LU/164/21/PL

Felix Dancewear, 39 Beach Road, Littlehampton, BN17 5JA

Part change of Use from office/storage on first floor to 1-1 bed flat (resubmission following LU/100/21/PL).

Drawing Title
Existing and Proposed Floor Plans

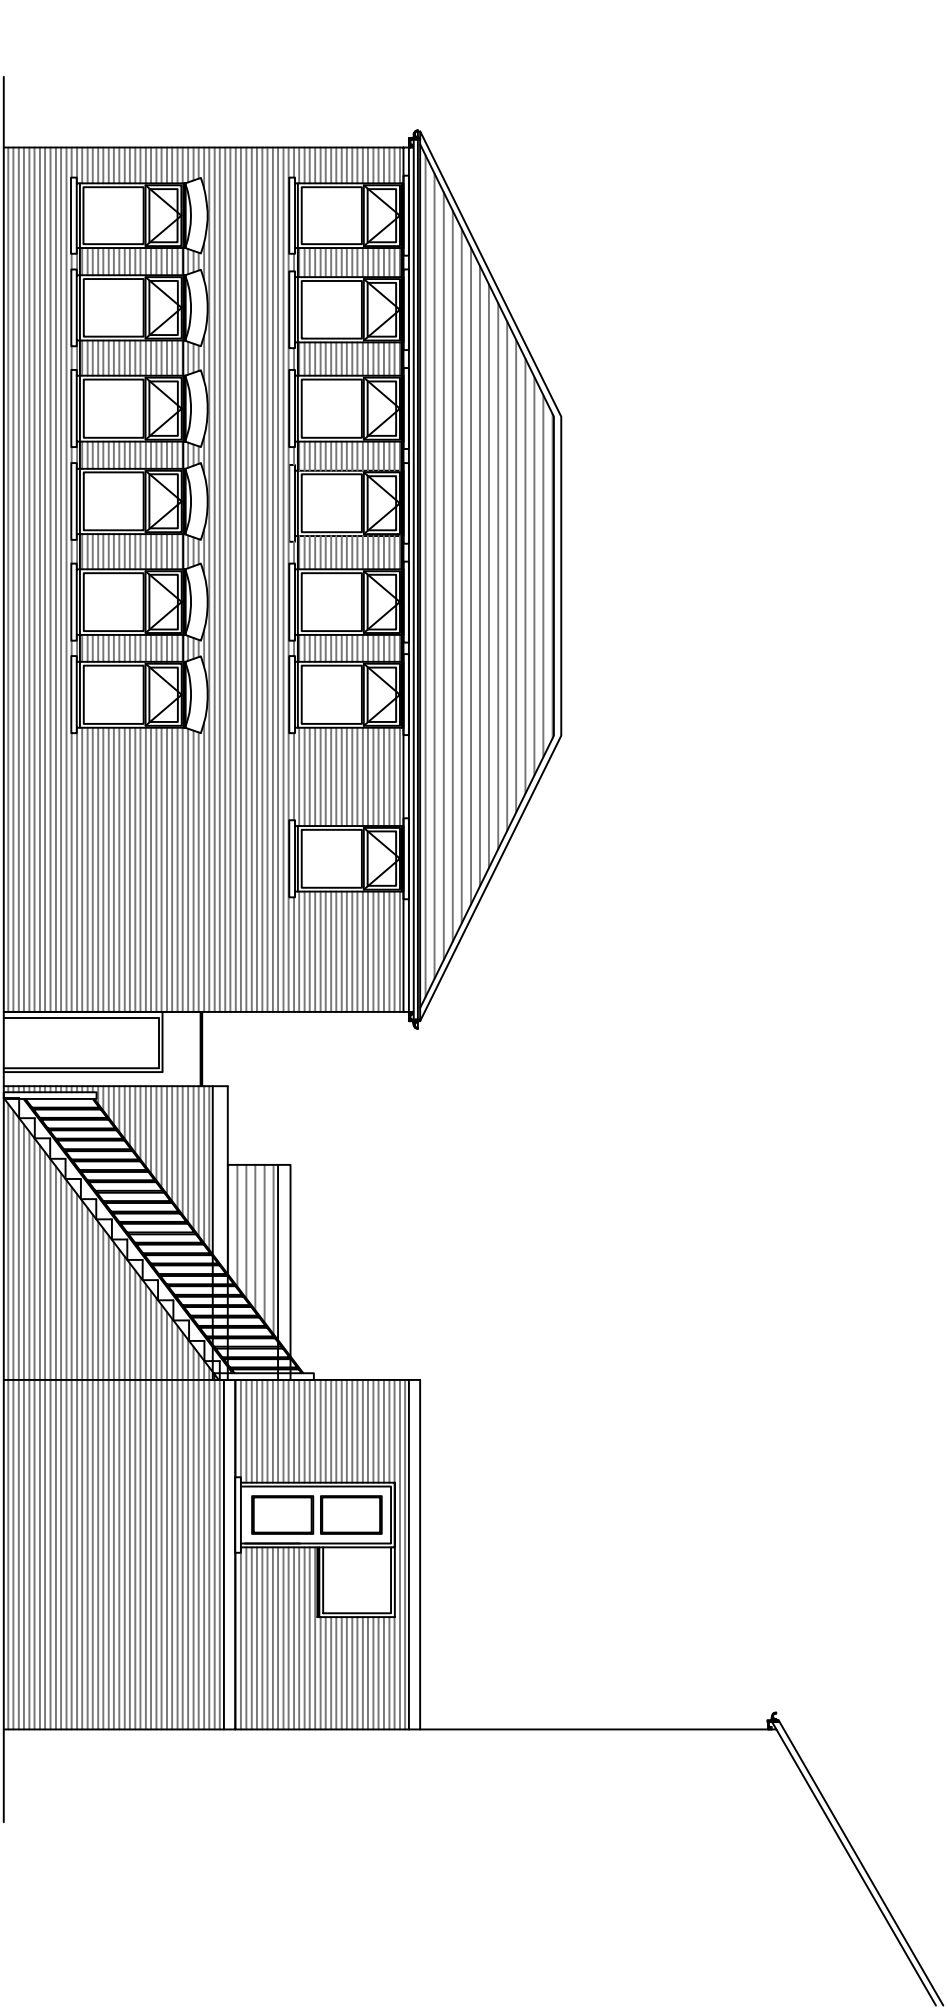
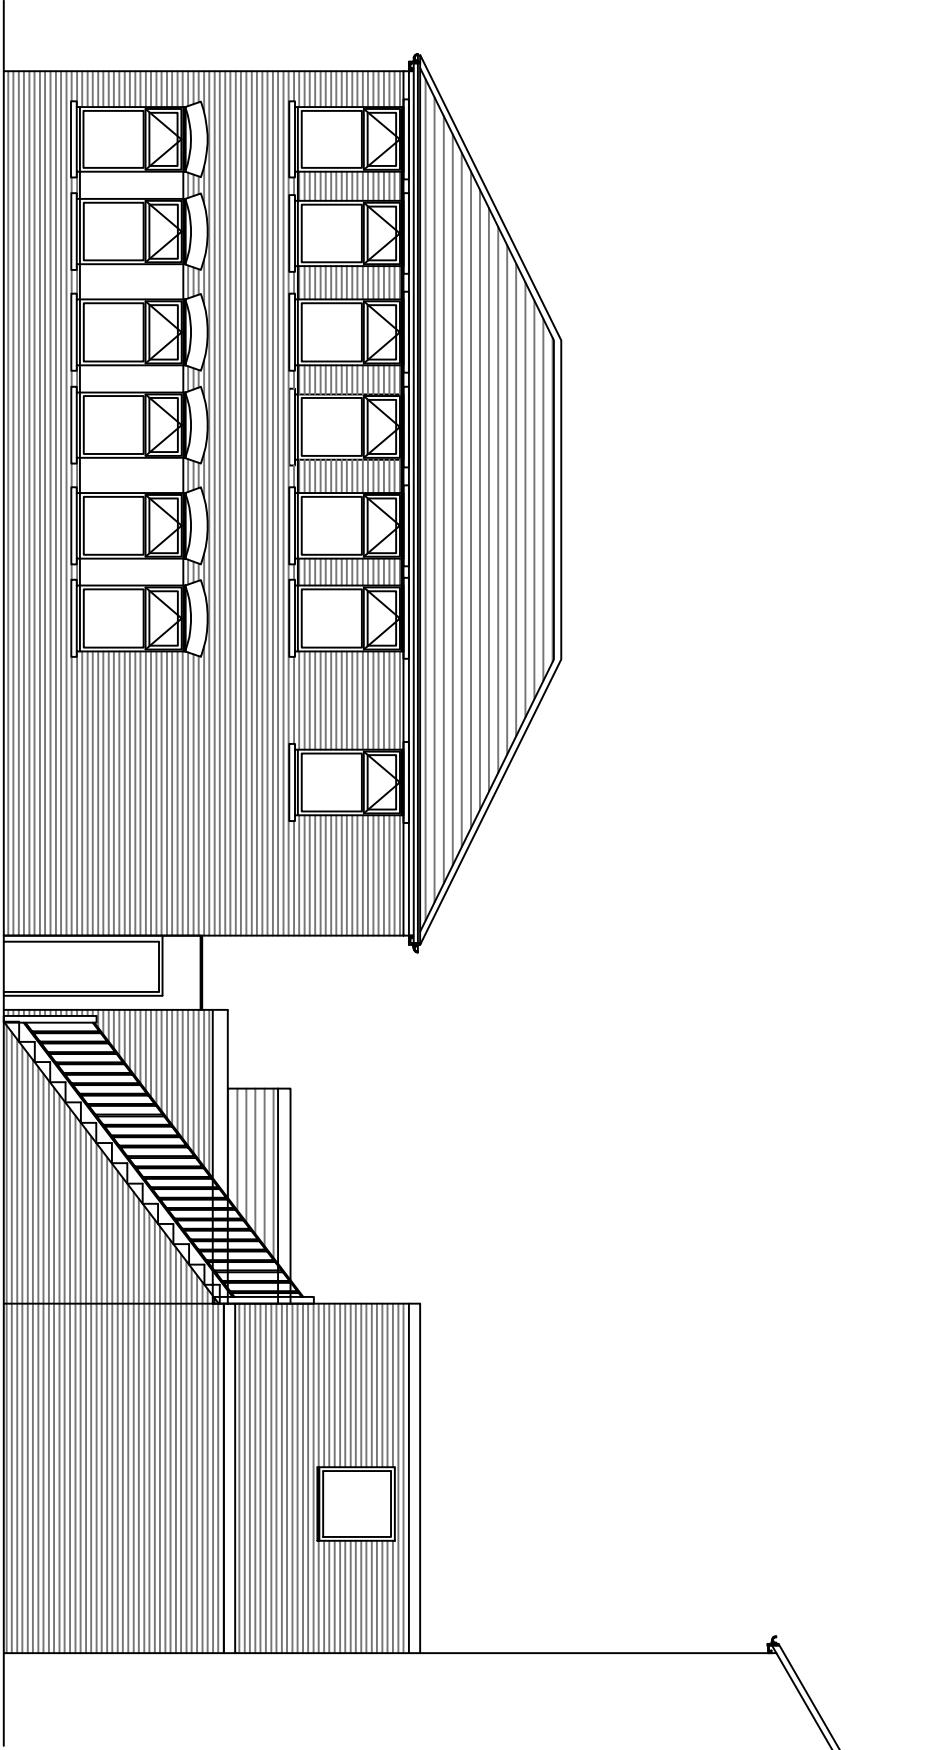
The proposal is for change of use from office/storage on first floor to a 1-bedroom flat. The proposed change of use would not cause harm to the building, based on the mix of uses in both the building and local area. However, from a conservation perspective, I would want the attractive first floor, front windows to remain. These add to the character of the building, and appear to be the only remaining original windows on the front elevation.
